Householder Application for Planning Permission for works or extension to a dwelling

Harcourt Avenue

Amendments Summary

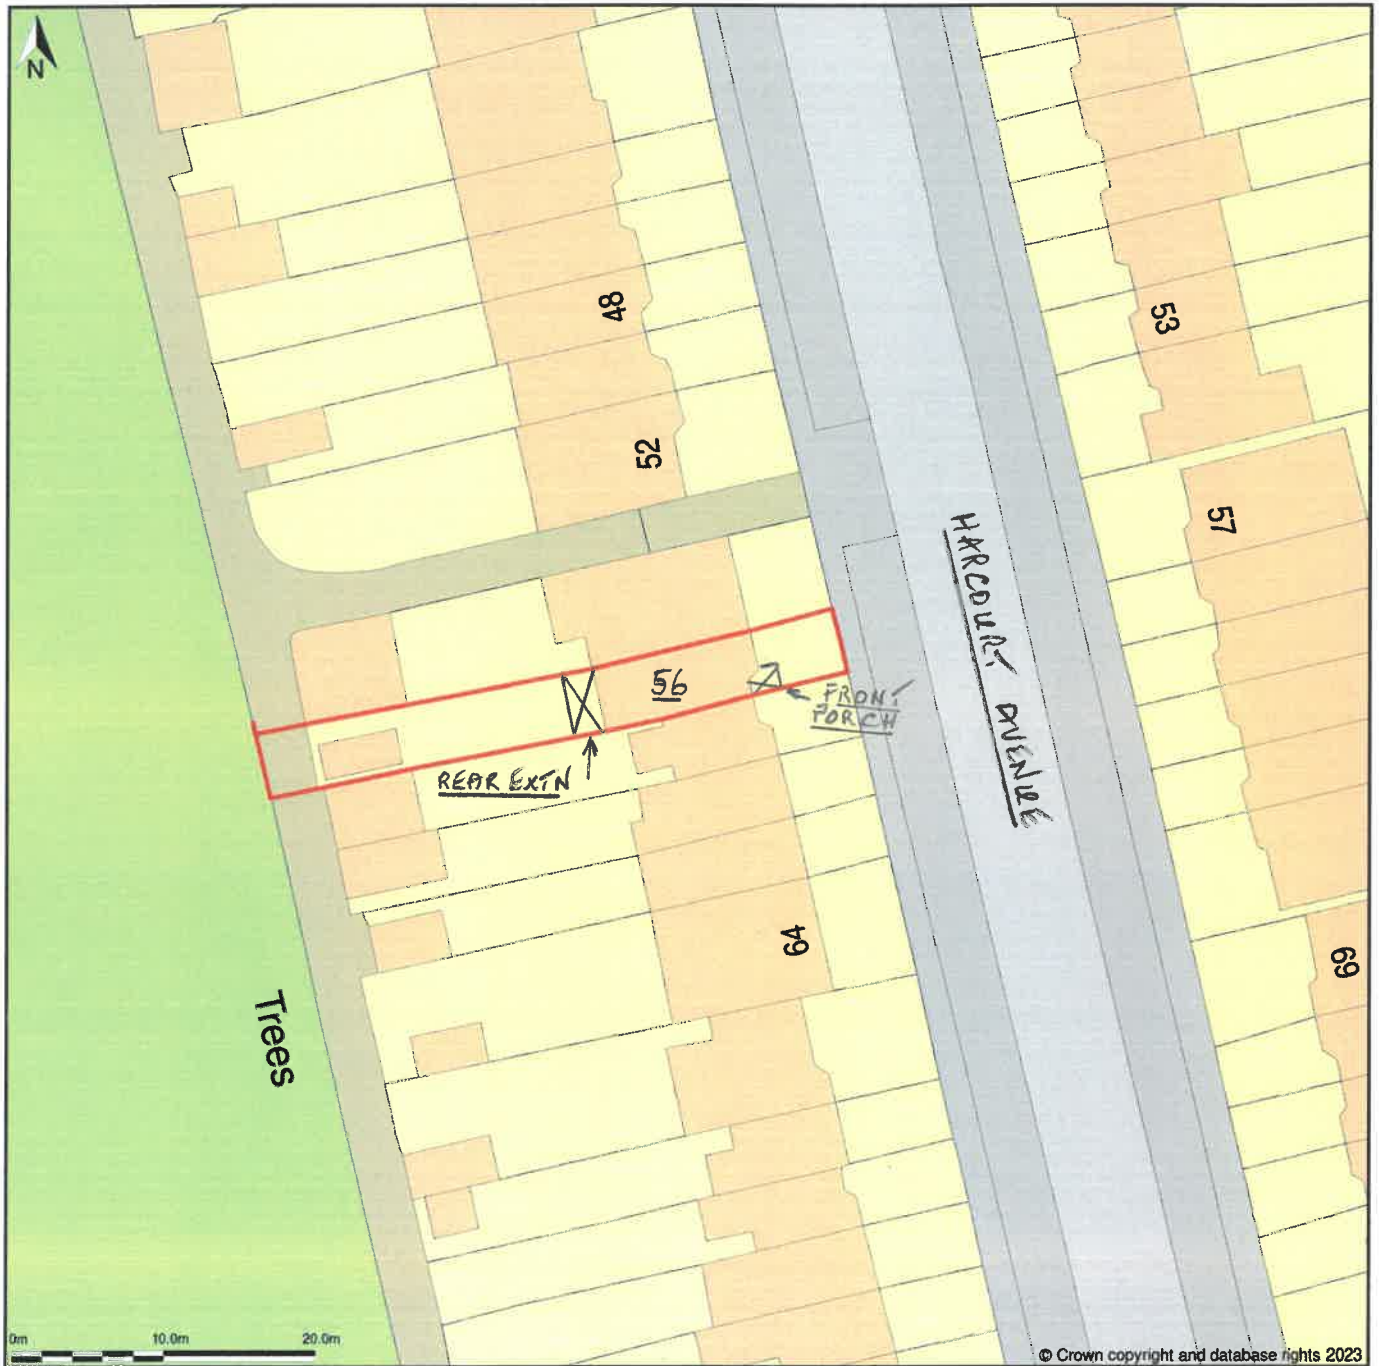
4 I can see that you have provided block plans but they need to be at a scale of 1:200 or 1:500, I can't see a scale bar for this. Please can one be included. I have added the scale to the block plan I provided and I have purchased and uploaded another block plan as well.

56 HARCOURT AVENUE  
 DA 15 9LN  
 PROPOSED SINGLE STOREY  
 REAR EXTENSION & PORCH  
 TO FRONT ELEV. DRG N°1A

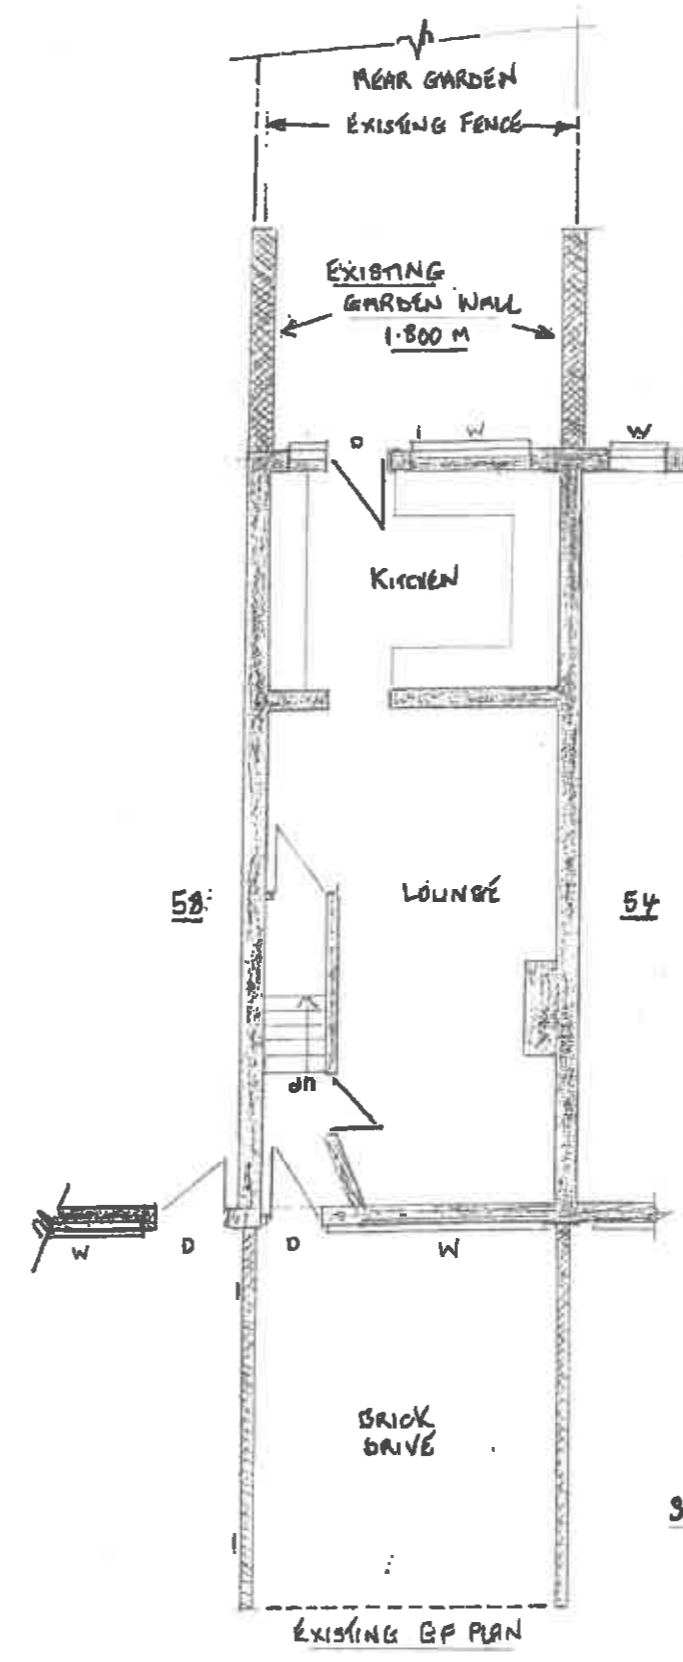
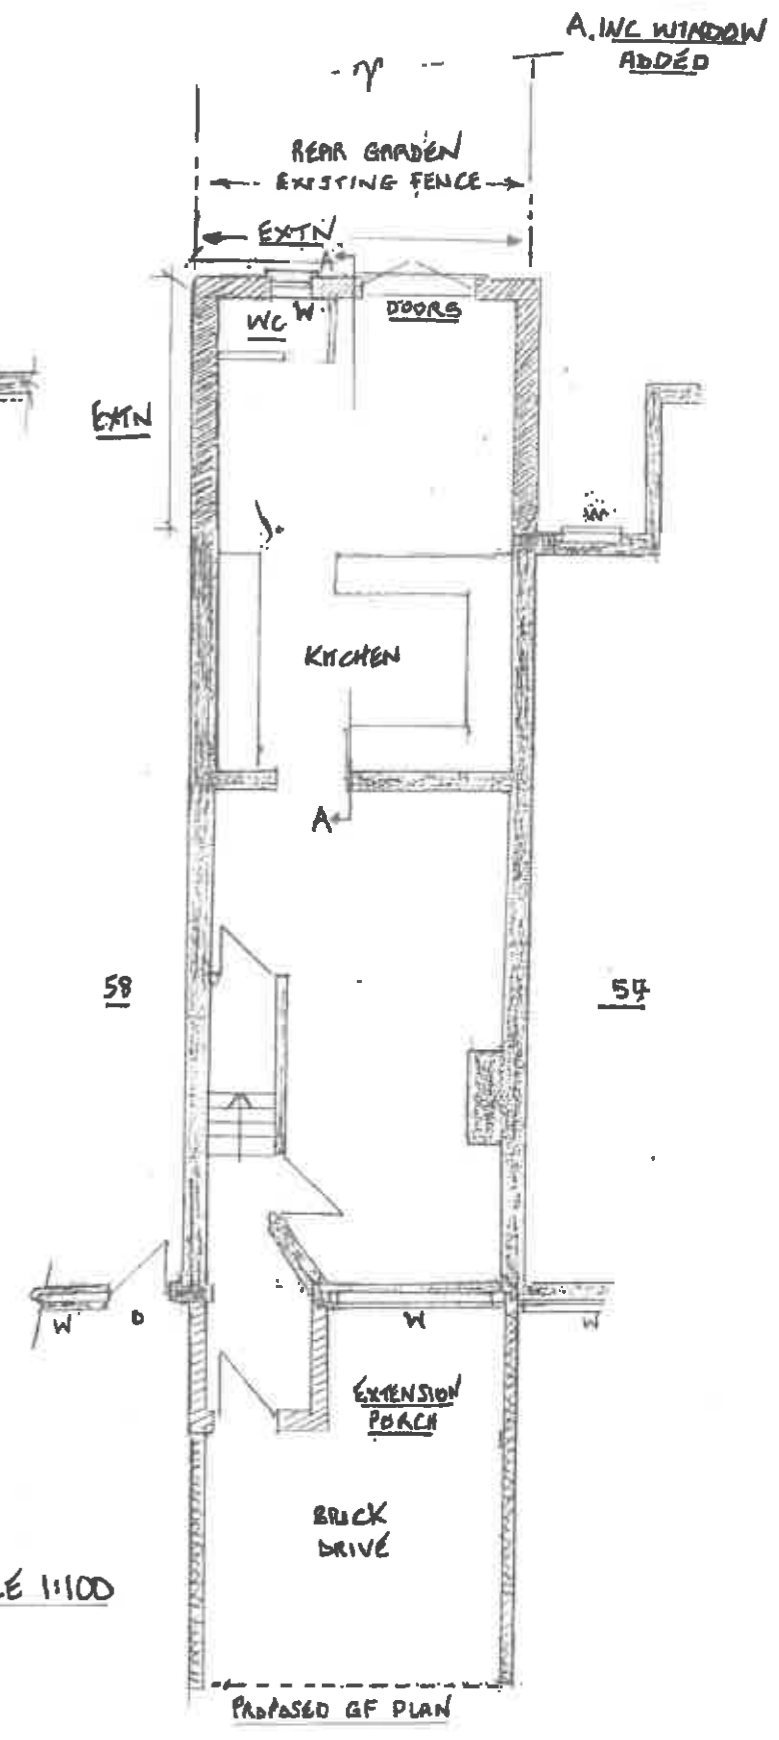
2 Can you please advise if you are adding a front porch to the house. If so please can this be amended to reflect on the plan if so. I have checked the form and it definitely states that the proposal includes the addition of a front porch.

56 HARCOURT AVENUE
DAIS 9LN
PROPOSED SINGLE STOREY
REAR EXTENSION & PORCH
TO FRONT ELEVⁿ DRG N^o 2

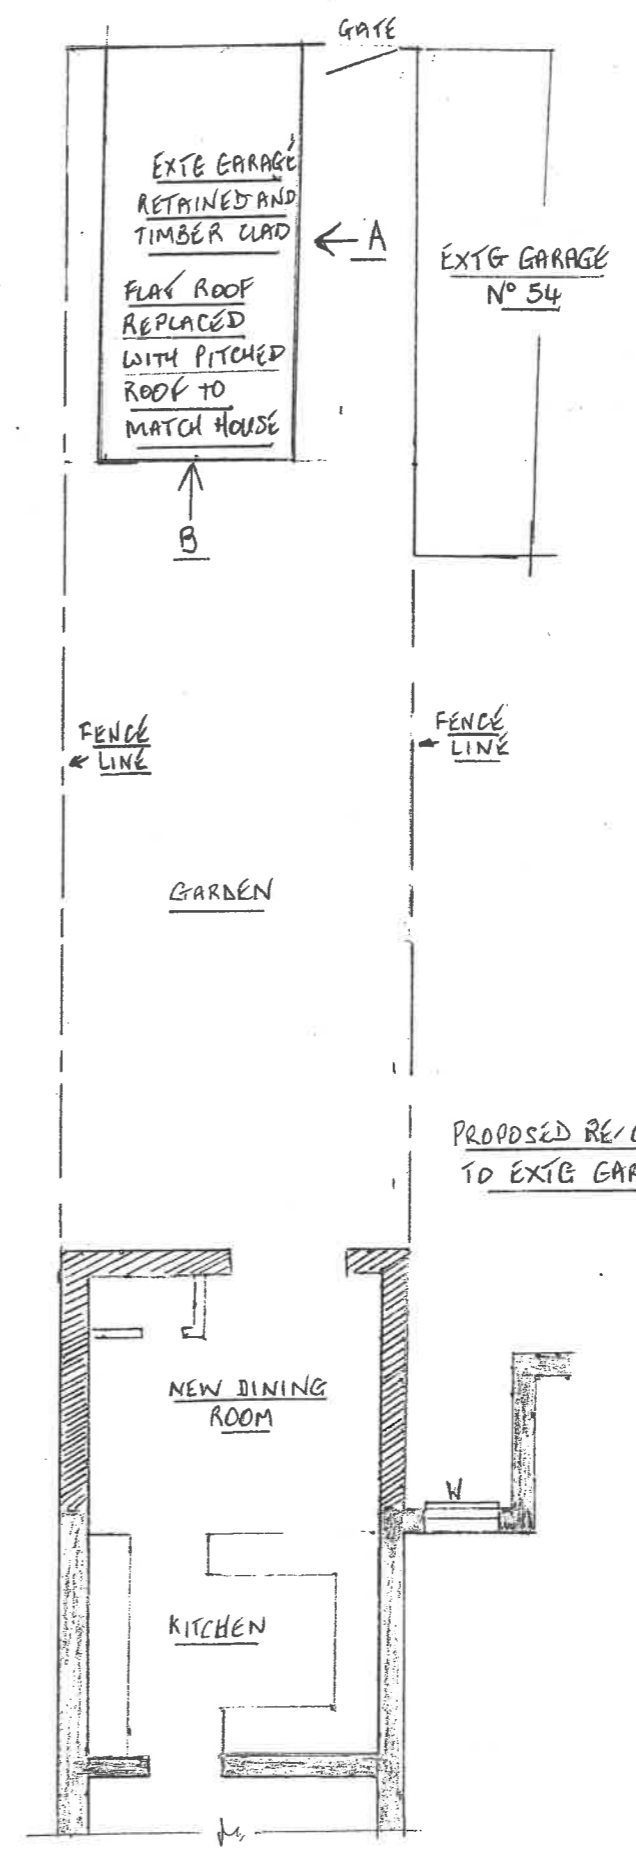
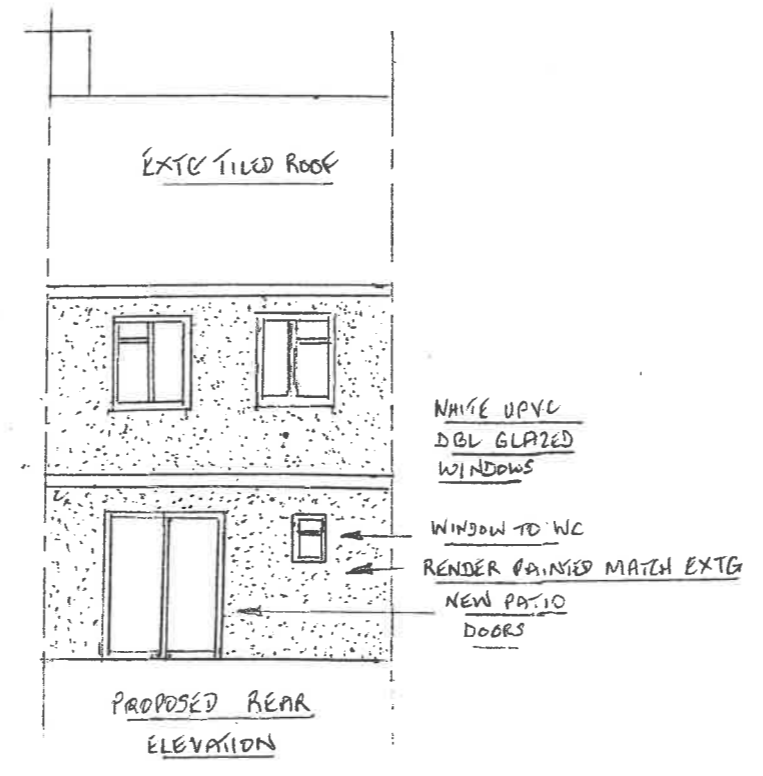
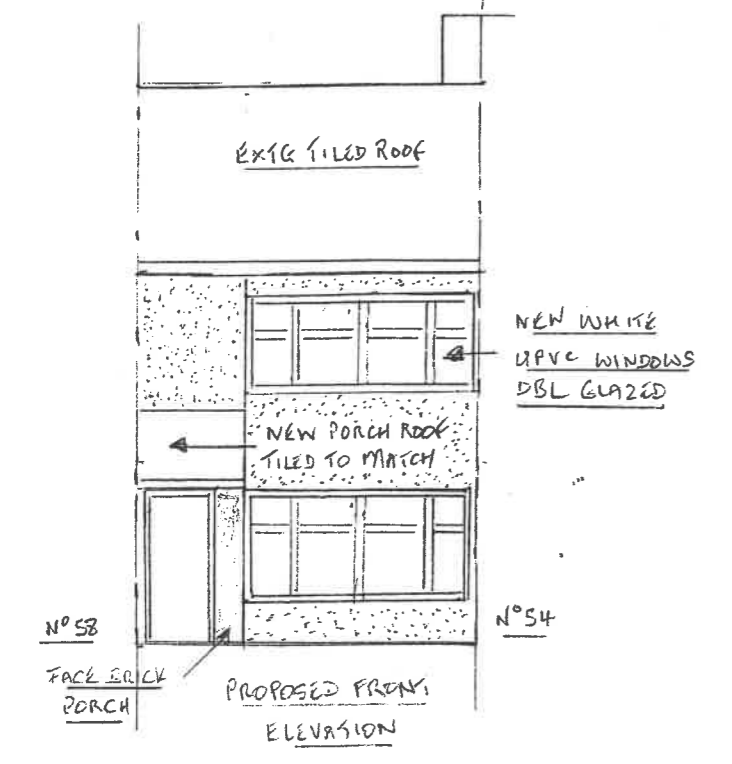
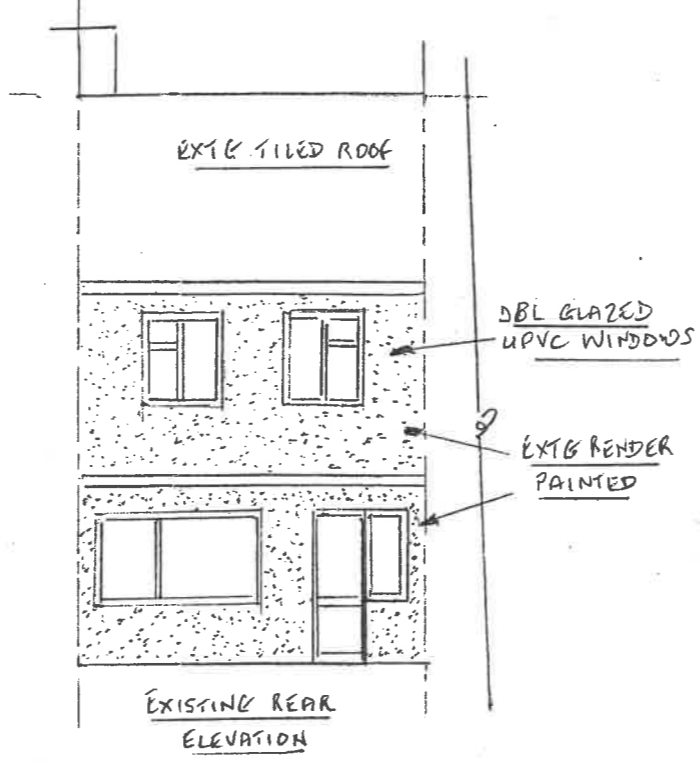
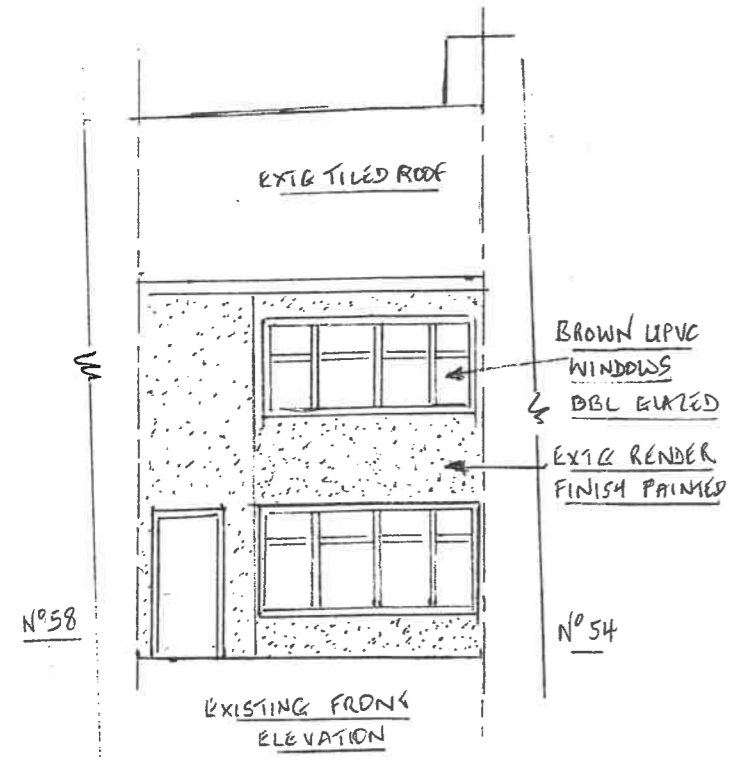
3 The existing rear elevation shows a window and a door but the plans only show a door. Please can this be altered. I've looked at the elevation and plan and as far as I can see the existing rear elevation on Drg 2 shows a door and sidelight and a separate window, and the plan on Drg 1 shows the same on the wall above the word Kitchen. Perhaps you were thinking it was the wall between the kitchen and lounge which does indeed only have a door opening. I hope this is satisfactory.
